Sanitary Survey Form
 Public Water System Well Site Inspection
 331-638 • Field Version

Water System Name	?	County	R. H. T. O. S.
Contact Person	Sheri Bay	Phone	206-484-2987
Address	13131 Salmon La Sac	Name of owner or representative present during inspection	Sheri Bay
Location of well (address or parcel number)	Game	Date Inspected	10-3-23
Inspected By	Melissa Schumaker & Holly Erdman	GPS Coordinates	10-3-23
Section/Township/Range/Quarter/Quarter	34 21 14

Comments: Shop structure in SCA must be used as well house otherwise well site must be moved. Move cul de sac out of SCA, check RV holding tank drain line location OK

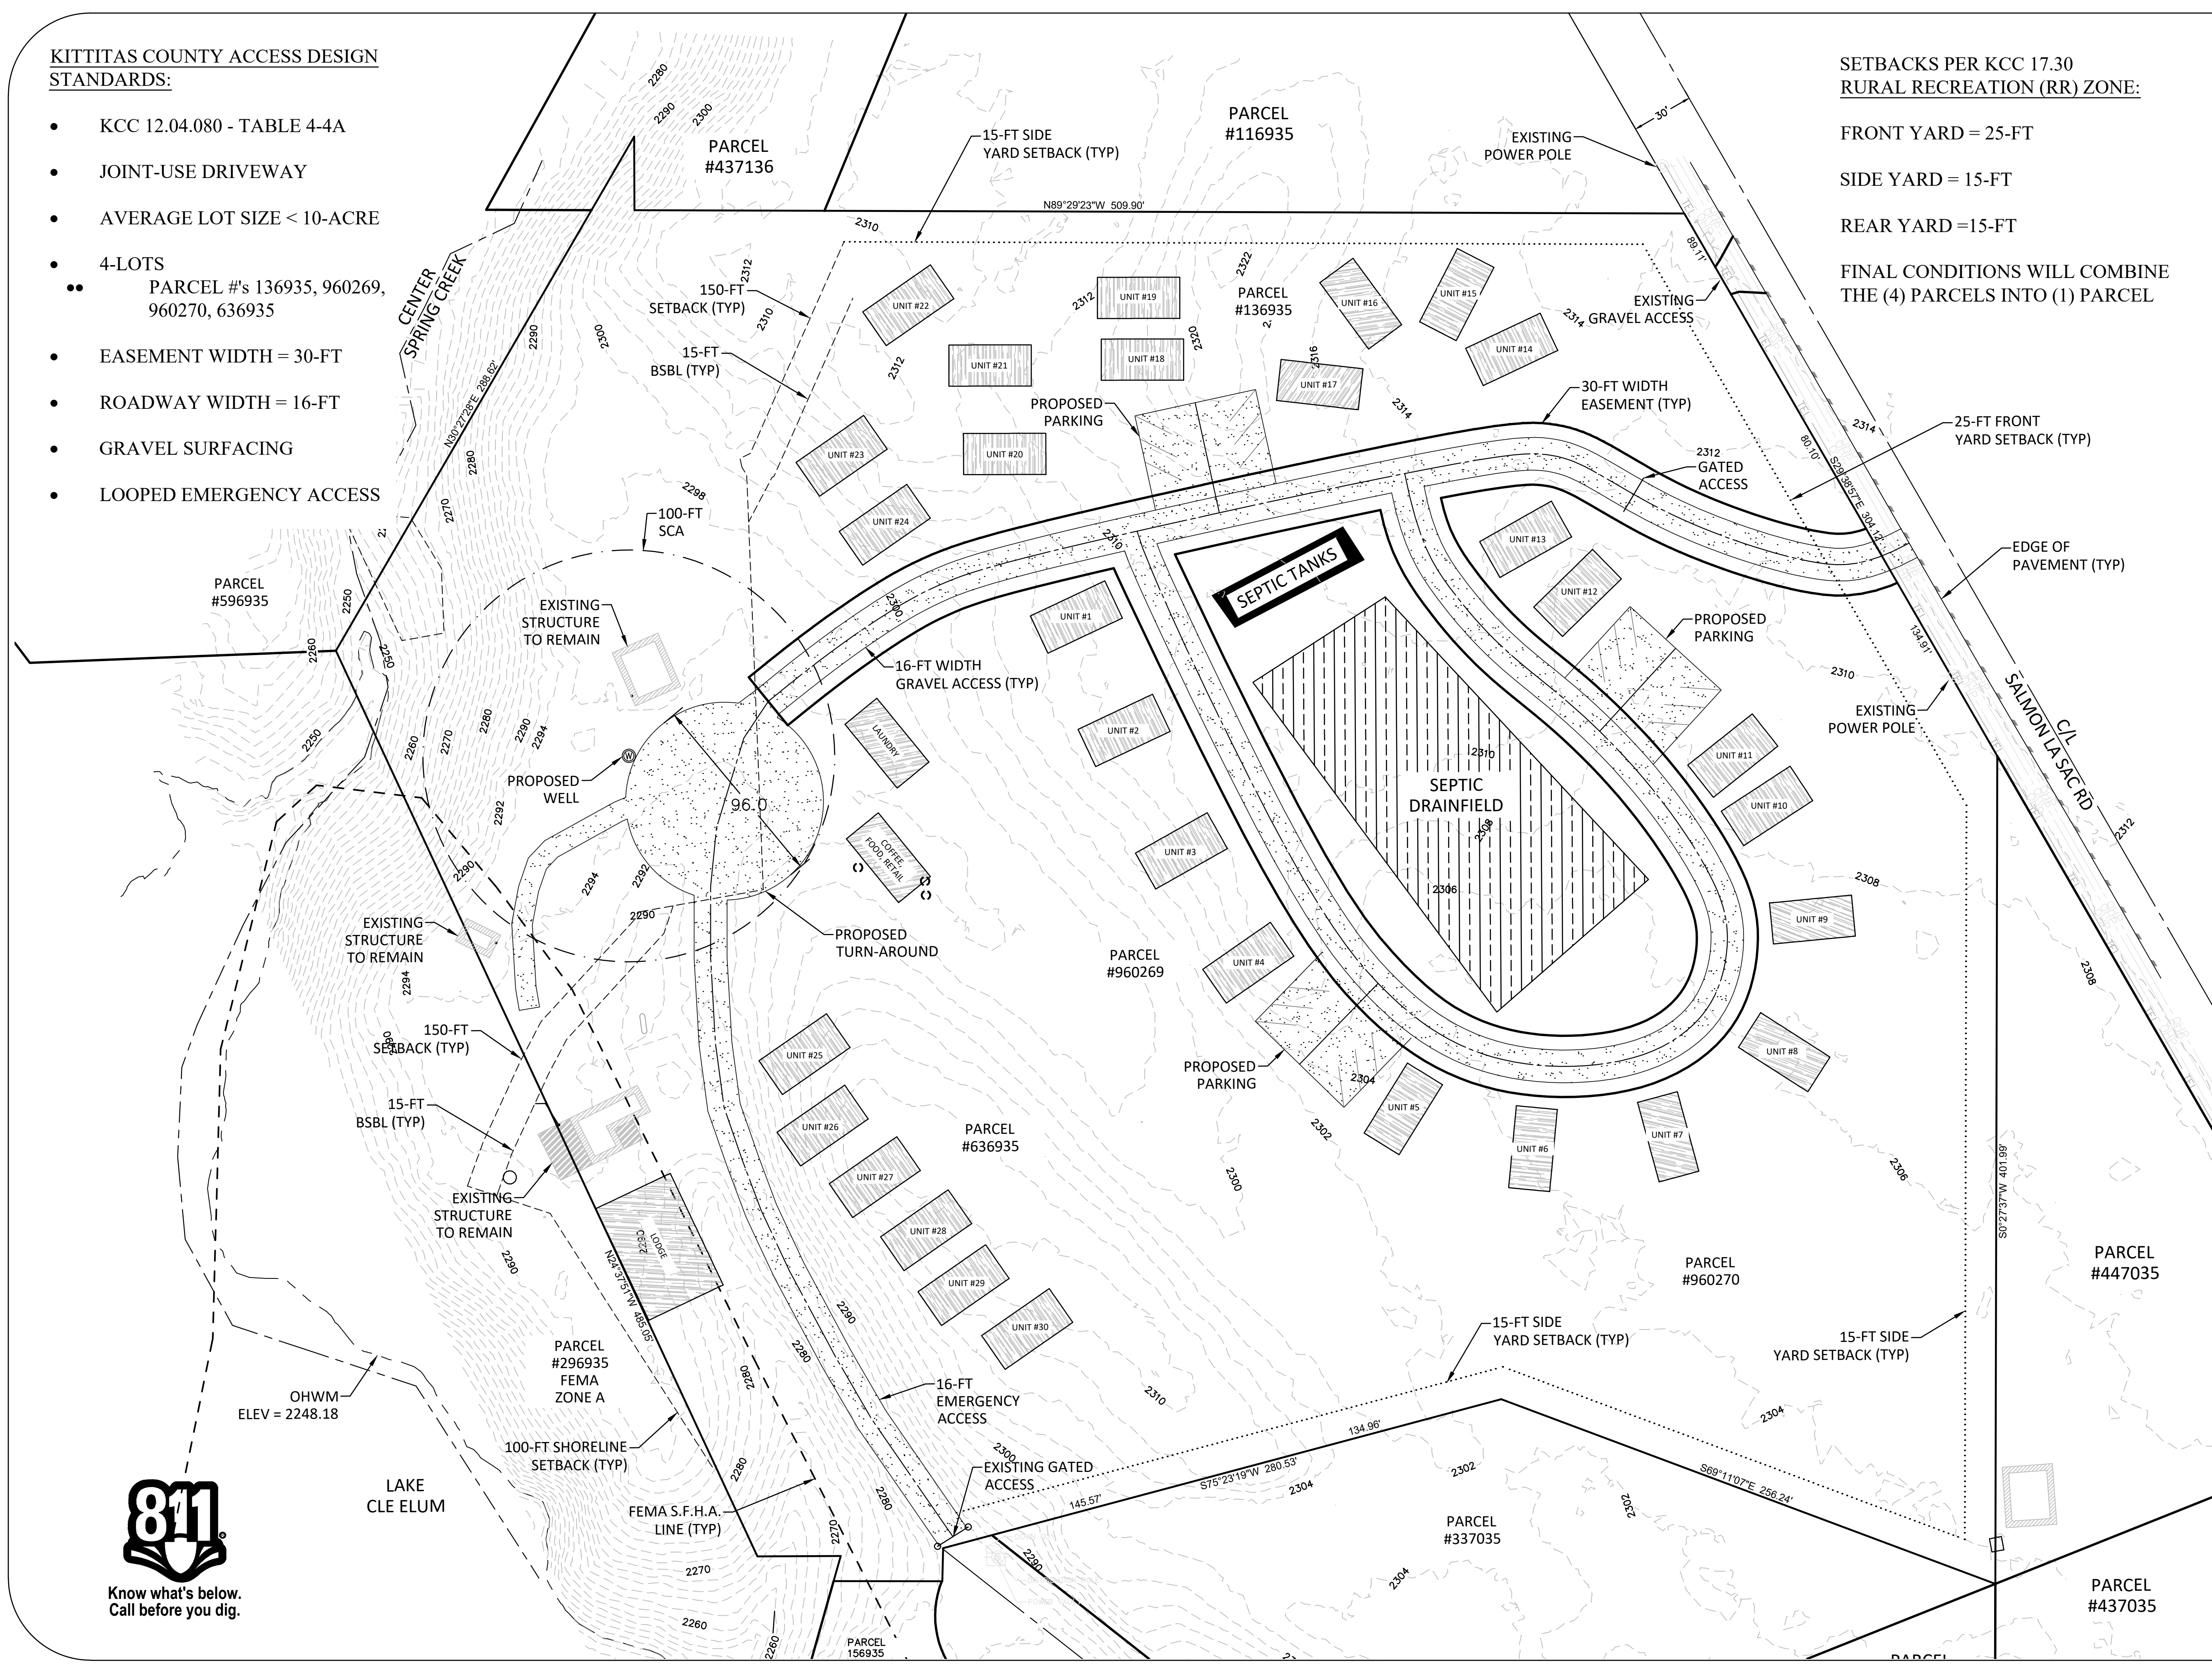
4. Avoided public or private roads as far as possible?	more cul de sac 100' away	Yes <input checked="" type="checkbox"/> No <input type="checkbox"/> N/A <input type="checkbox"/>

6. Contamination sources, such as septic tanks, chemicals, underground storage tanks, surface water, and dry wells are absent from well site?	check holding tank drain line	Yes <input type="checkbox"/> No <input type="checkbox"/> N/A <input type="checkbox"/>
